KIRKLEES METROPOLITAN COUNCIL INVESTMENT & REGENERATION SERVICE

DELEGATED DECISION TO DETERMINE PLANNING APPLICATIONS

Reference No:	2026/62/90976/W
Site Address:	21, New Hey Road, Marsh, Huddersfield, HD3 4AL
Description:	Erection of two storey rear extension and first floor side extension with car port below
Recommending Officer:	Joanna Rednall

DECISION – CONDITIONAL FULL PERMISSION

Drawing:
Proposed Level 1 and 2

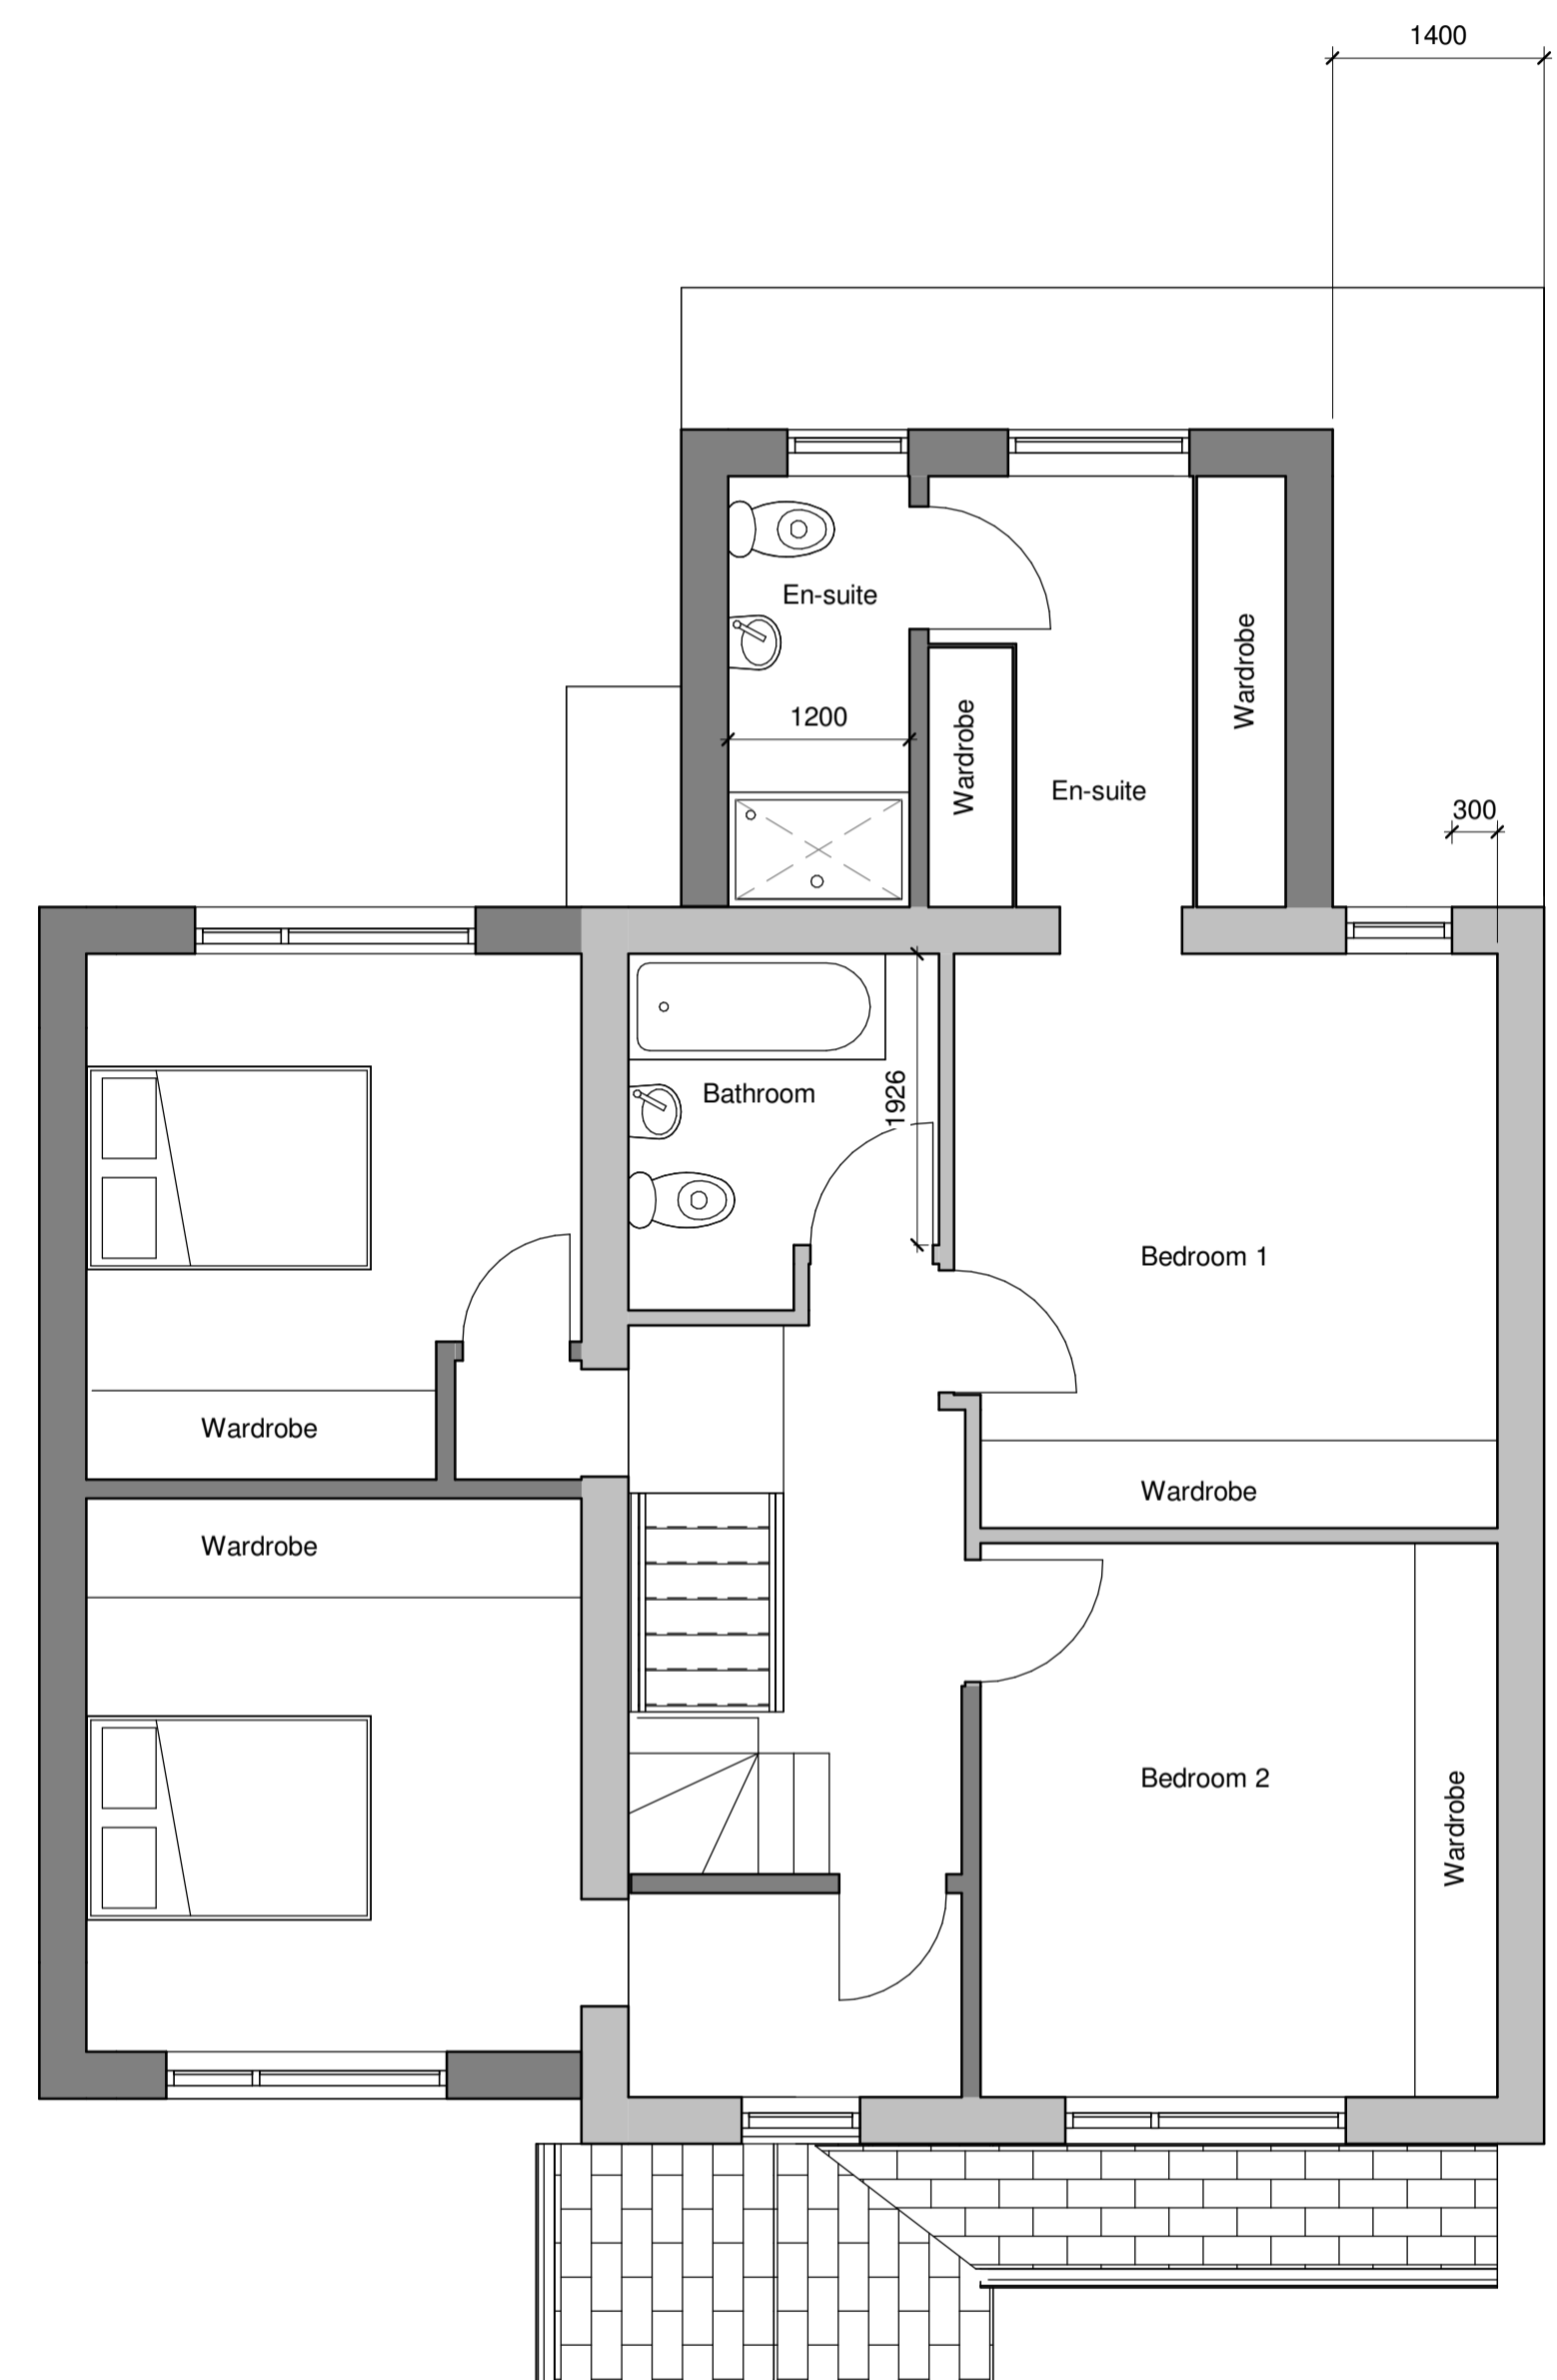
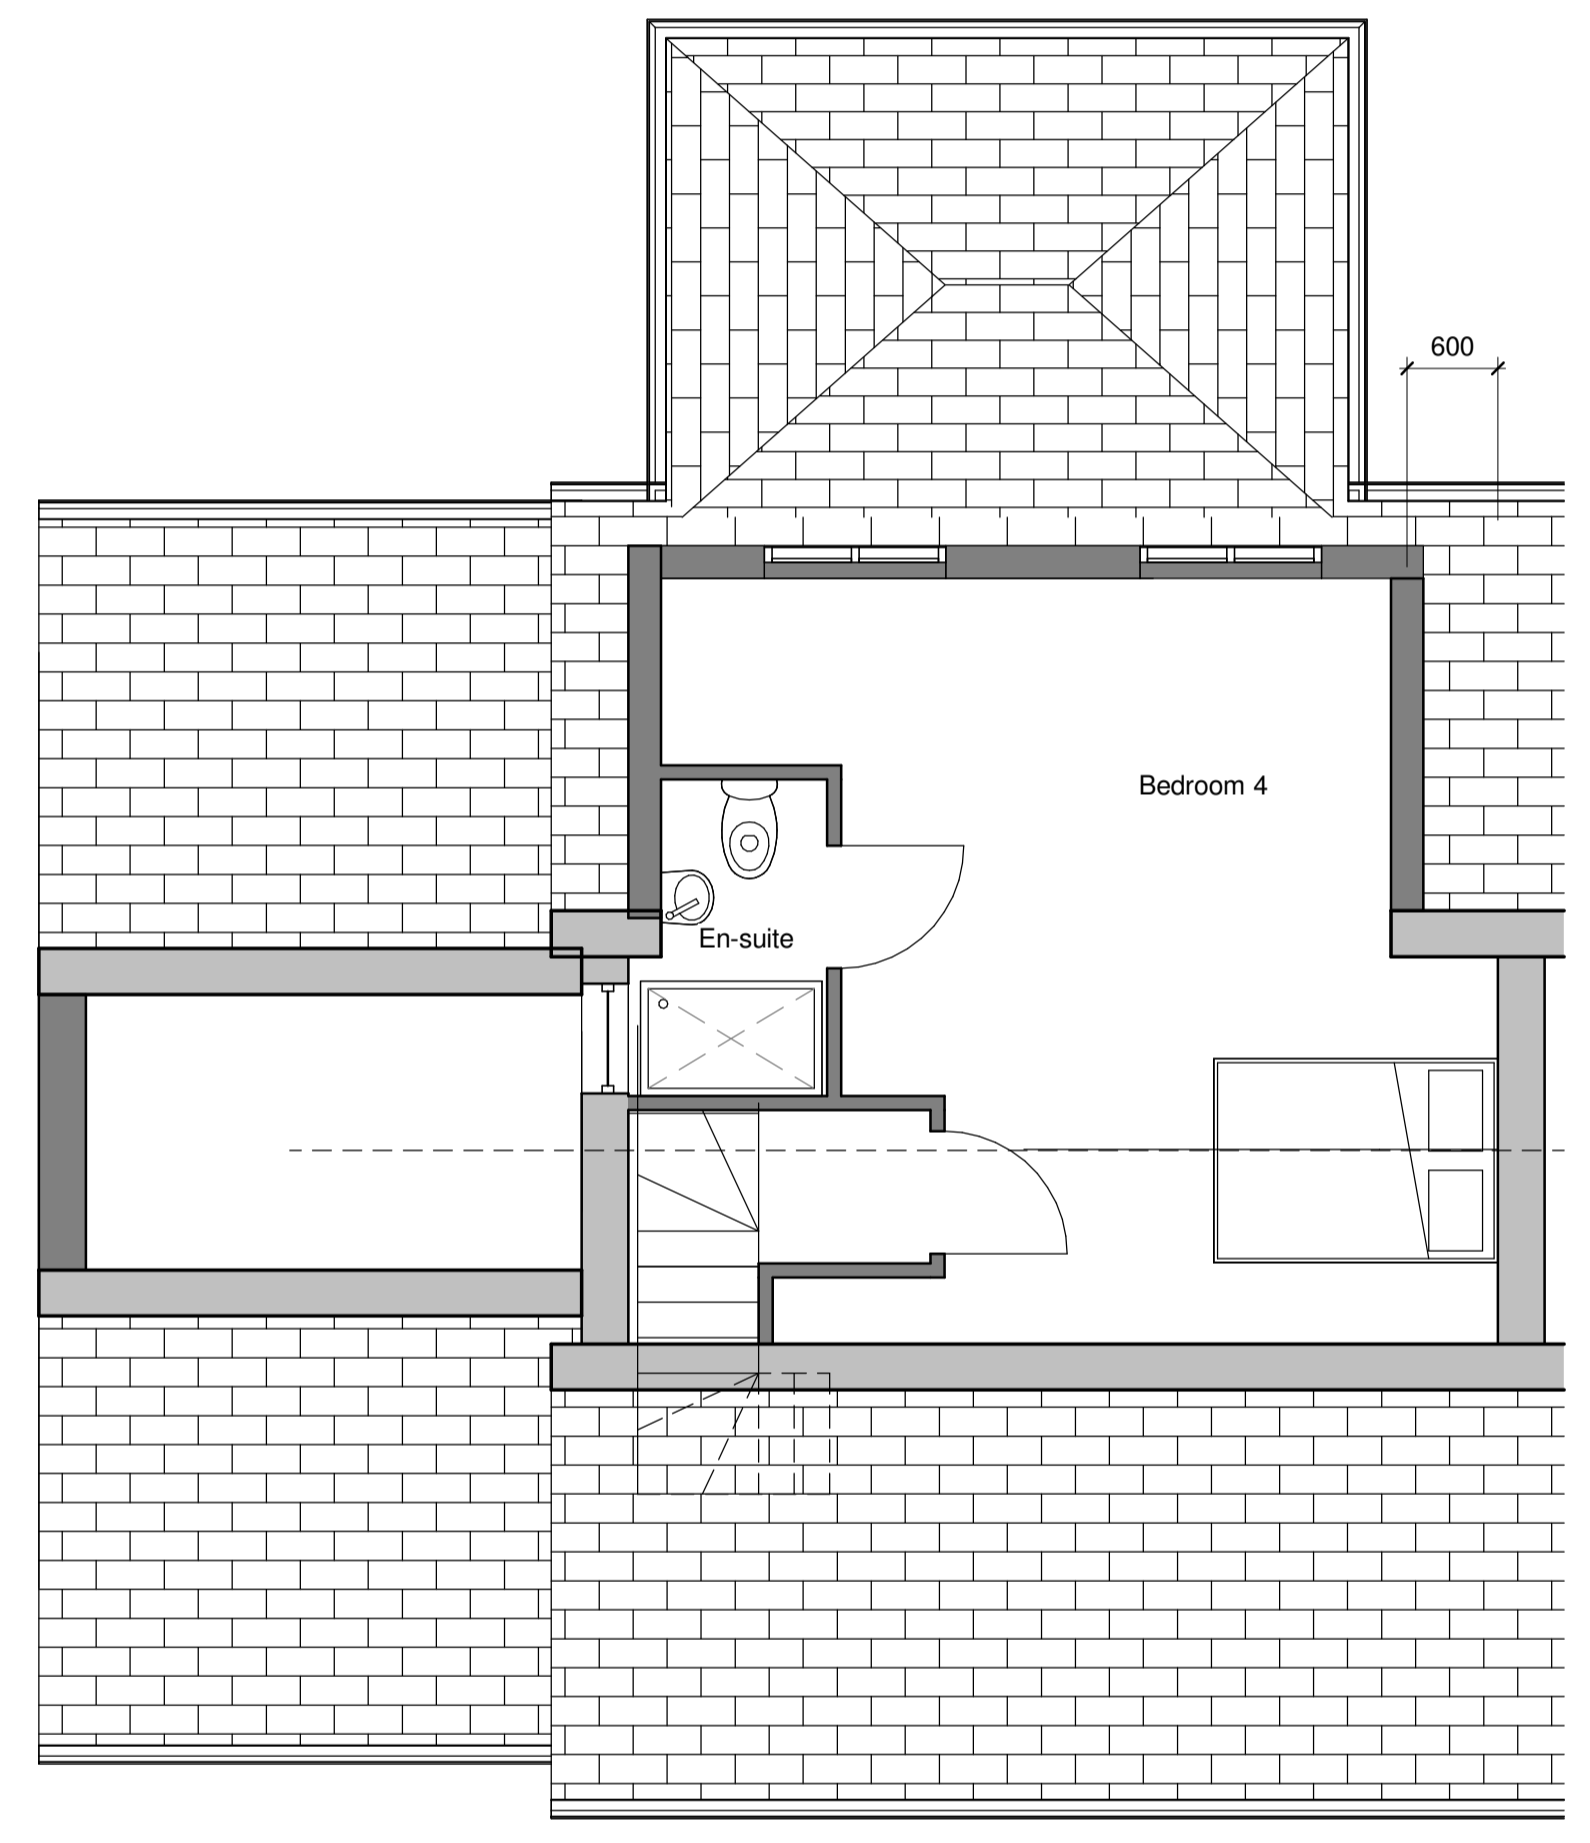
Minor amendments were made to the material proposed to elevations to ensure that the proposal would adequately harmonise with the host. The amended plans also demonstrated a revised roof design to the side extension and also reduced the size of the first floor element of the two storey extension to rear. Amended plans were received on 5 June, and the application has been progressed to determination on the basis of these.

The second-storey element of the proposal would be set approximately 3.6 m from the shared boundary, providing a significant degree of separation at upper level. This offset, combined with the existing extension at No.23, helps to limit any perception of overbearing massing or undue enclosure. Given the absence of new facing windows, the compliance with the 45-degree line, and the separation distance at first-floor height, the development is not considered to result in harmful impacts in terms of overbearing, privacy, or loss of light for the occupiers of No.23.

The openings facing this property at the first floor level would be a bedroom which is no closer to no.11 than the existing bedrooms windows in the rear of the host property and a bathroom which would be 1m closer. Given the non habitable nature of the window closer at the first floor level, and that screening can mitigate any overlooking at the ground floor level the proposal is not considered to lead to an unacceptable level of overlooking to this property.
